CITY OF PORTLAND, MAINE  
 DEVELOPMENT REVIEW APPLICATION  
 PLANNING DEPARTMENT PROCESSING FORM  
 DRC Copy

2004-0217  
 Application I. D. Number  
 10/19/2004  
 Application Date  
 Joseph Ave  
 Project Name/Description

RE: Joseph Avenue – 172-F-001, 002, 003 – R-3 zone – new single family dwelling – permit application #04-1585

BOUNDARY SURVEY

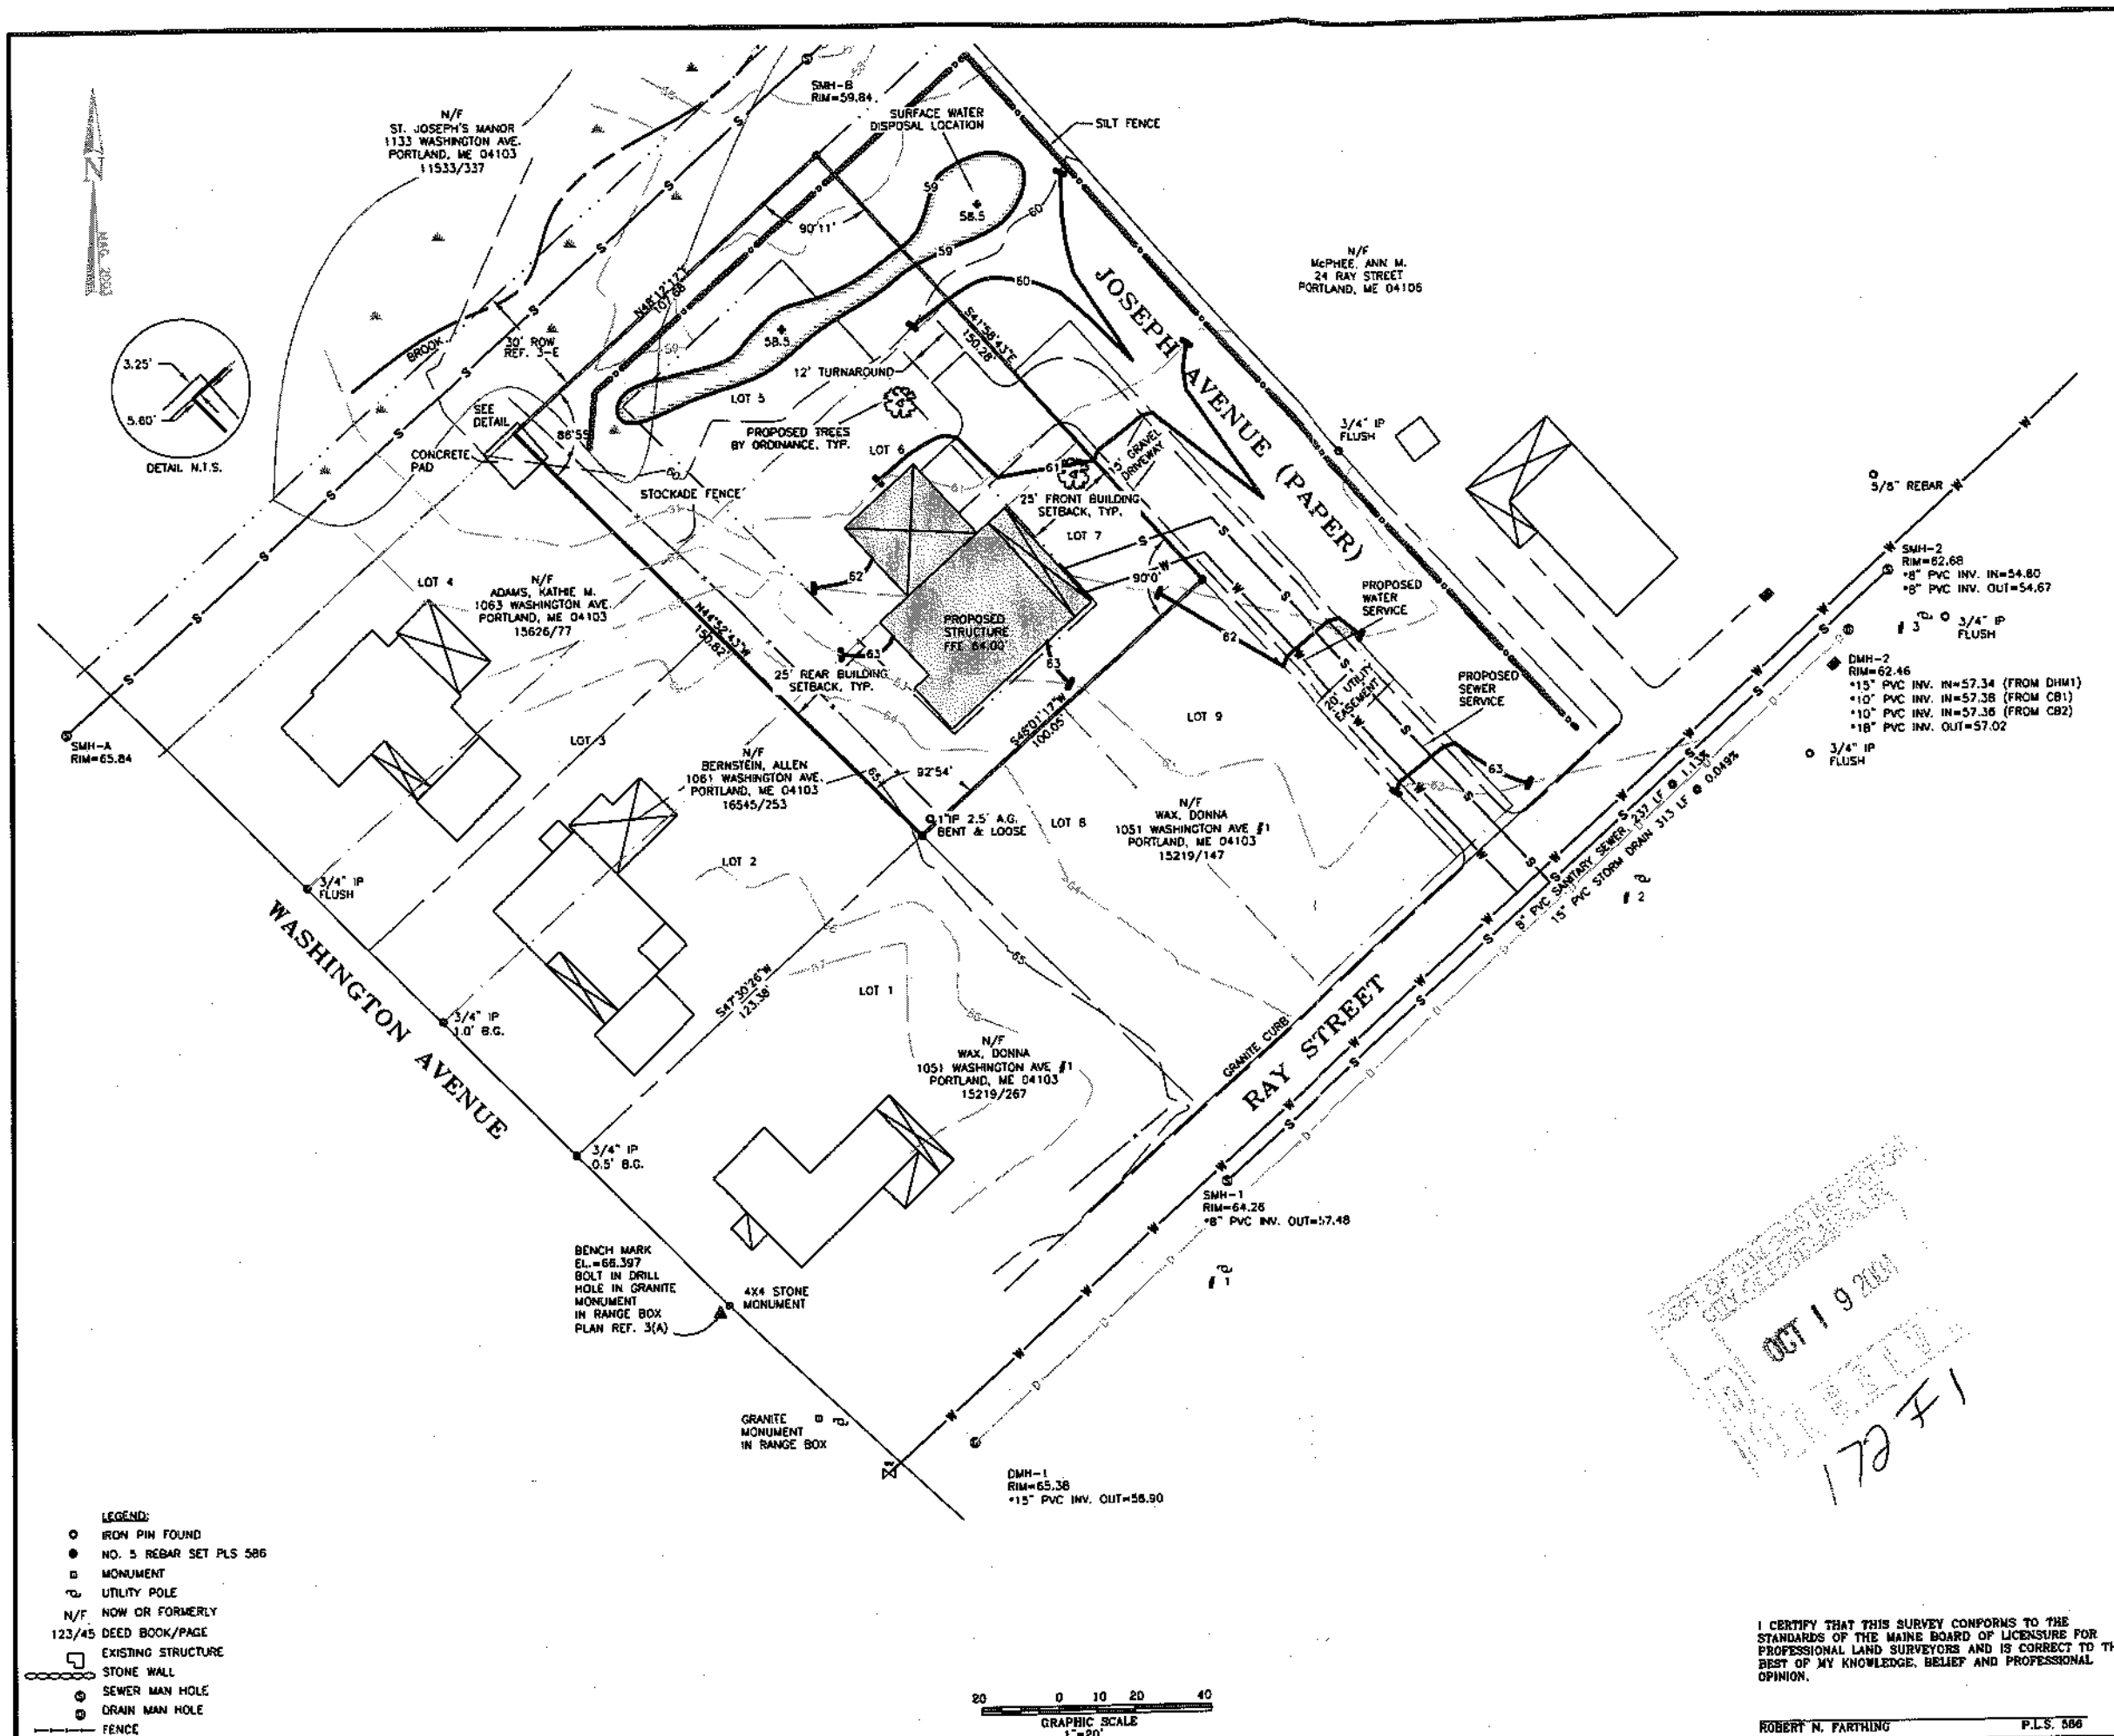
First, your site plan does not match your building plans. All dimensions shall match before a permit application can be adequately reviewed. It is also noted that there is a rear sliding door with no rear deck or stairs being provided. ALL structures that are to be approved as part of this permit application SHALL be shown on both the site plan and the structural plans.

Secondly, Joseph Avenue is a paper street as designated on your submitted plans. Section 14-403 of the ordinance states that the construction of a new housed shall trigger the requirement to upgrade the street to City standards. There is only one exception that this office has not received from you. Section 14-403 states, "The provisions of this subsection (b) shall not apply to the erection of any single-family dwelling on any lot where the owner of the lot establishes that he or she was the owner of that same lot on November 19, 1984, and at all times thereafter, and states his or her intention under oath to make the structure his or her personal residence". Your application submittal did not include such an affidavit. If you believe that all sections of the exemption allowance pertain to your application, it will be necessary to submit an appropriate affidavit to this office. If you cannot meet the requirements of the exemption, it will be necessary to show this office how Joseph Avenue is being brought up to City standards with the appropriate drawings.
